Please ask for: Mrs D Johnson
Email: daun.johnson@arun.gov.uk
Telephone: 01903 737762
Our Ref: BR/250/21/PL
Your Ref:
Date: 29th October 2021

Application for Planning Permission

Development: Ground & first floor extensions. This site is in CIL Zone 4 (Zero Rated) as other development.
Location: Unit 5 Dickinson Place Bognor Regis PO22 9QU

DRAWING
LOCATION PLAN

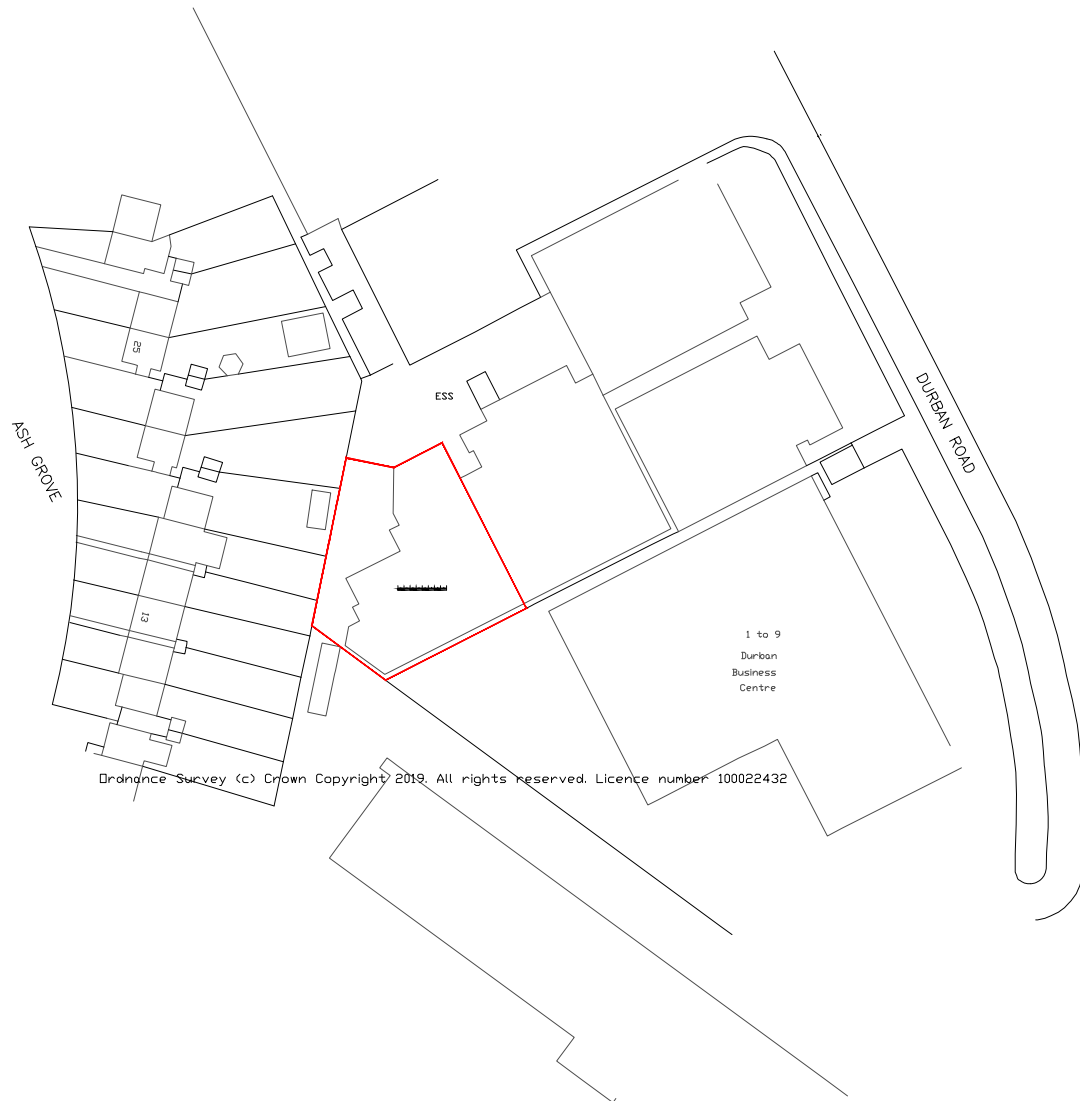
Location Plan

Please provide one named road.
